From: Anita Gardner
Sent: 26 February 2018 12:27
To: Karen Parsons
Subject: FW: FW: Proposed KFC at Fontwell - LPA ref WA/88/17

1. It would appear that there are proposed extension/changes planned for the Burger King. This is shown both on the Proposed General Arrangement Plan dwg 217052-A200 and also Proposed Site Layout Plan dwg 217052 A000.

drawing no. 217052 - A102	revision
-------------------------------------	----------

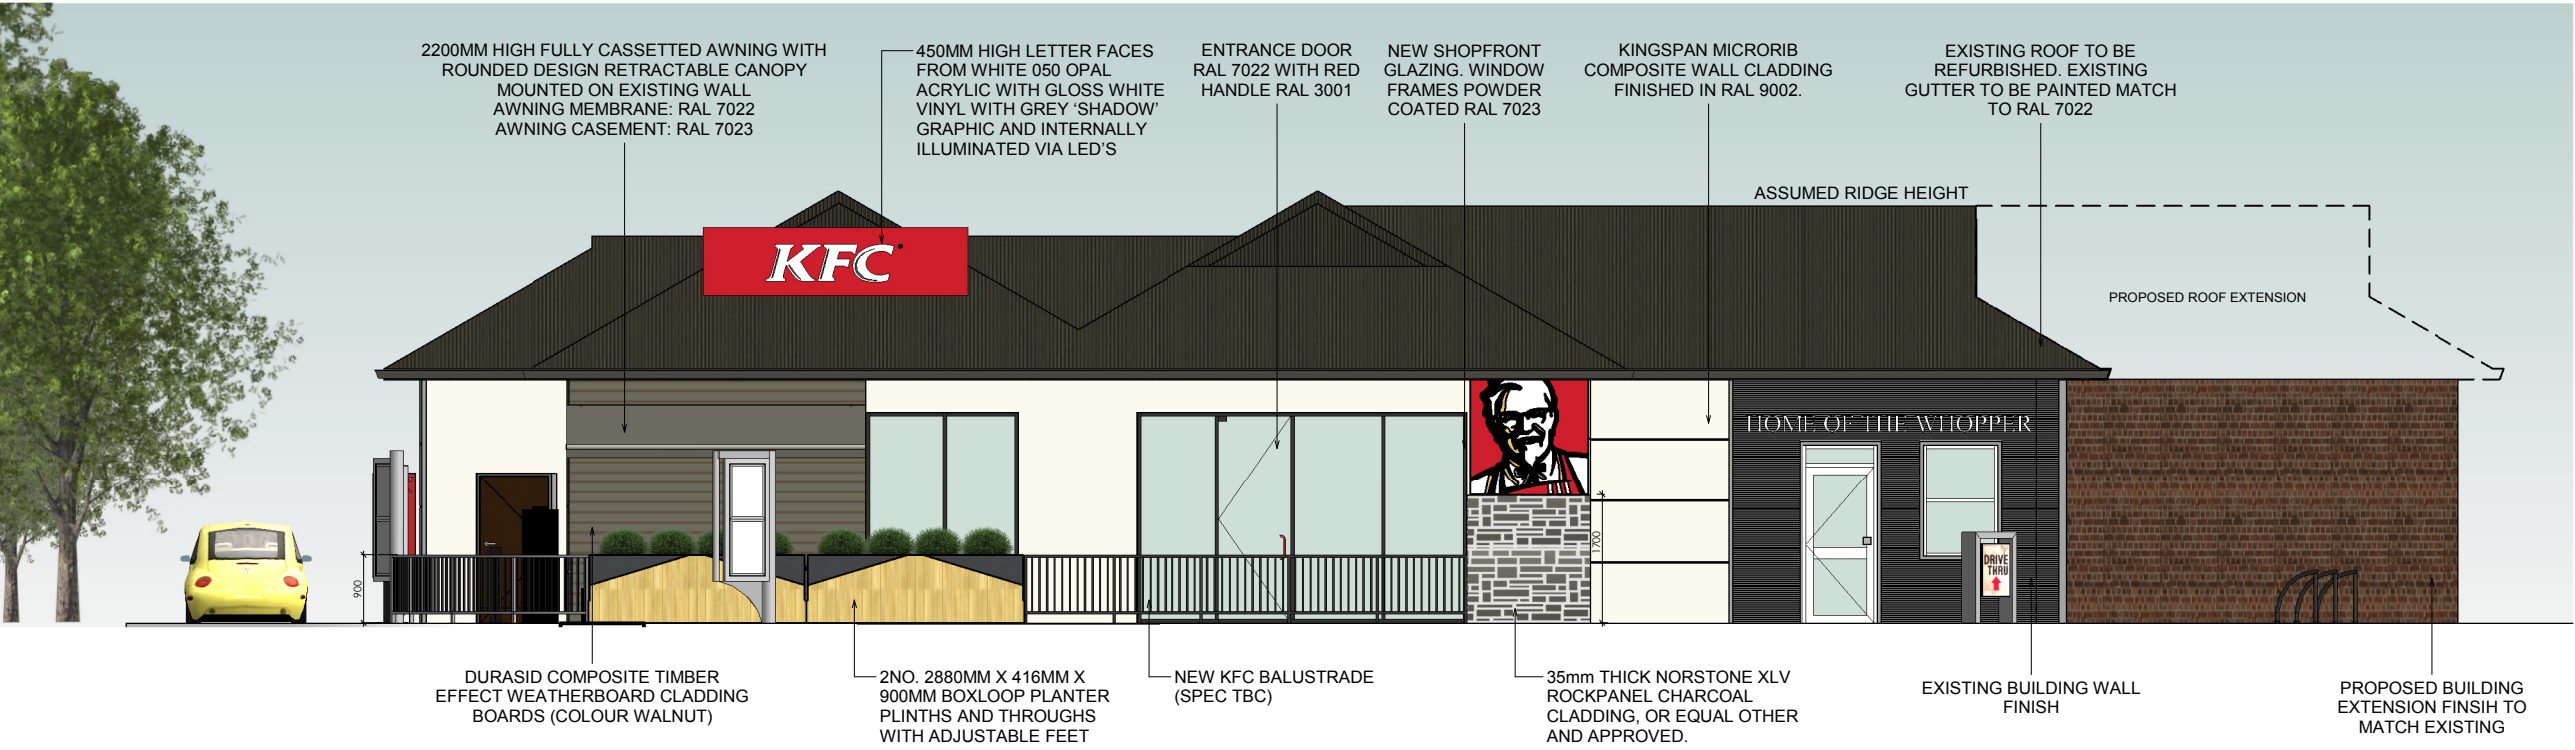
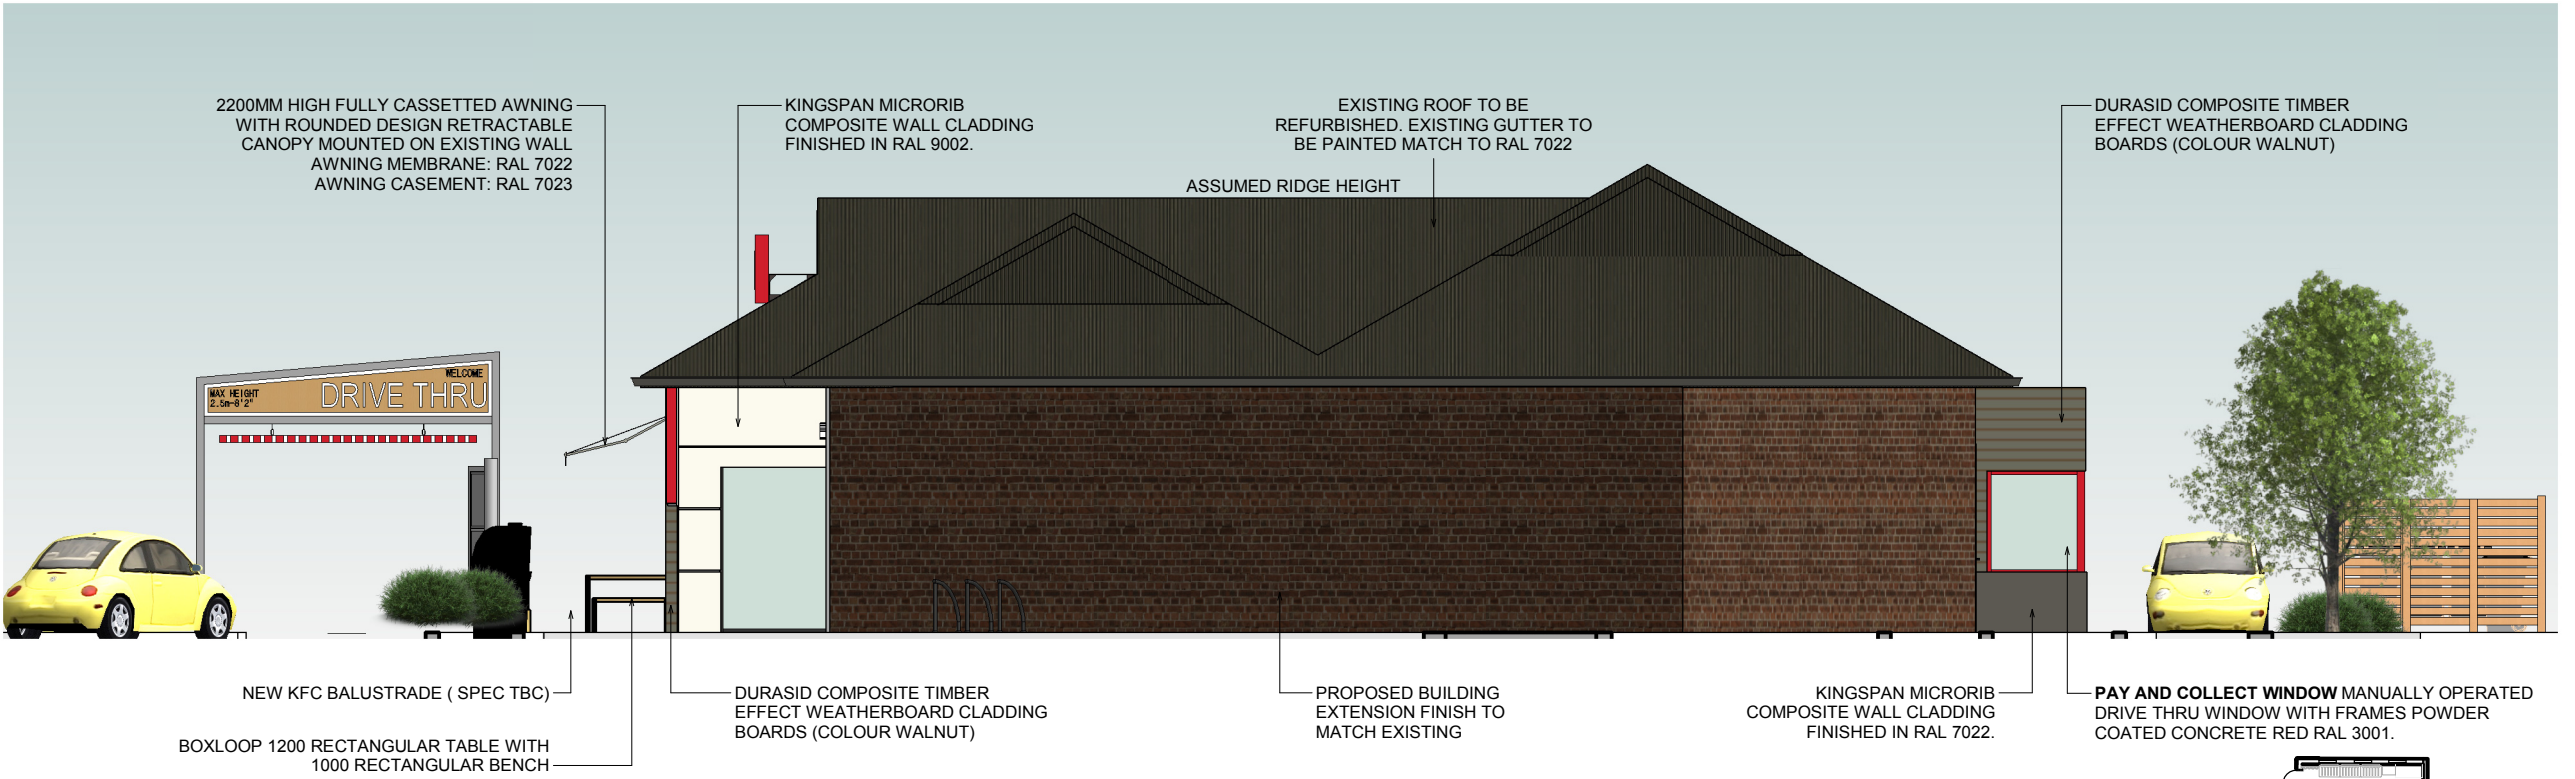
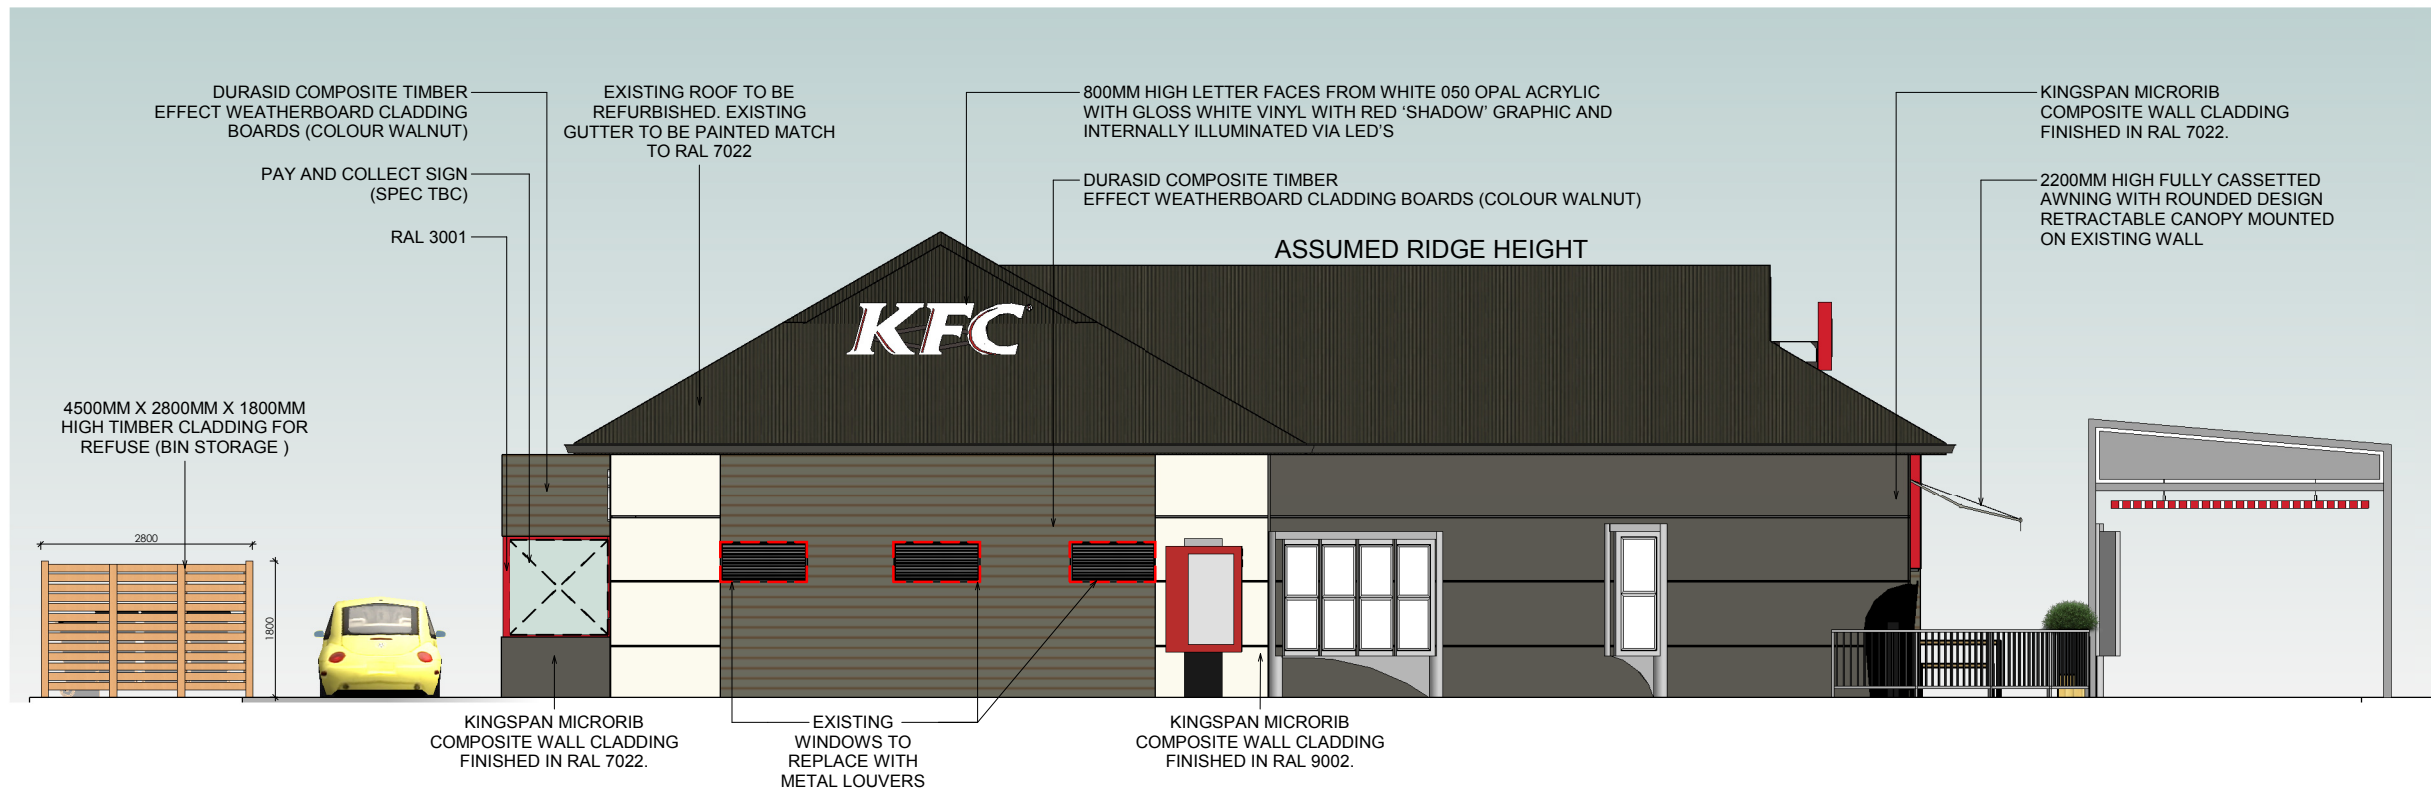
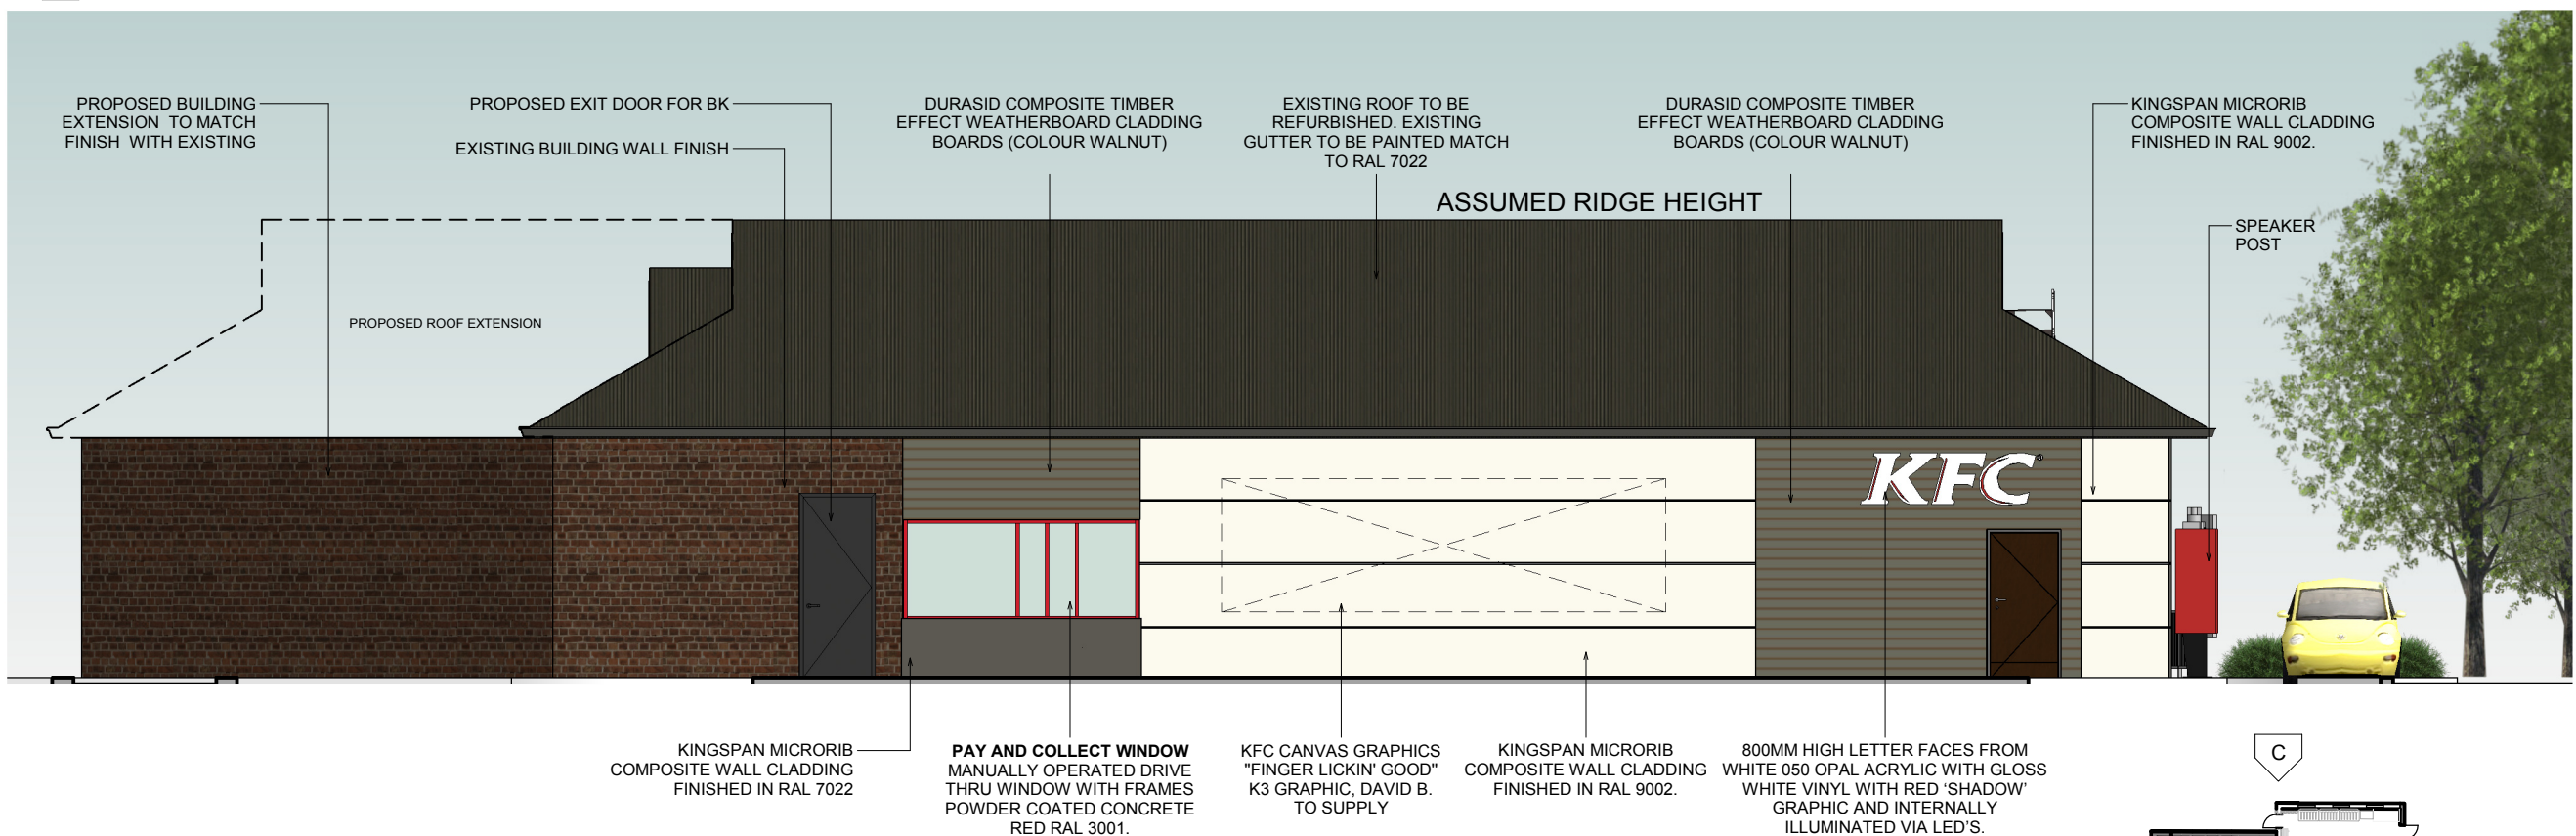
The plans do clearly refer to the proposed General Arrangement Plan and Exterior Elevations and should be deleted from the application drawings. The annotation does not state 'possible future extension which will be subject to a separate application'. It implies the extension is included. The application will need to be determined at Committee given the Objection from the Parish Council and the plans could cause confusion.

1. There are no external alterations or extensions proposed to Burger King. There may be an internal refit but no external changes are proposed
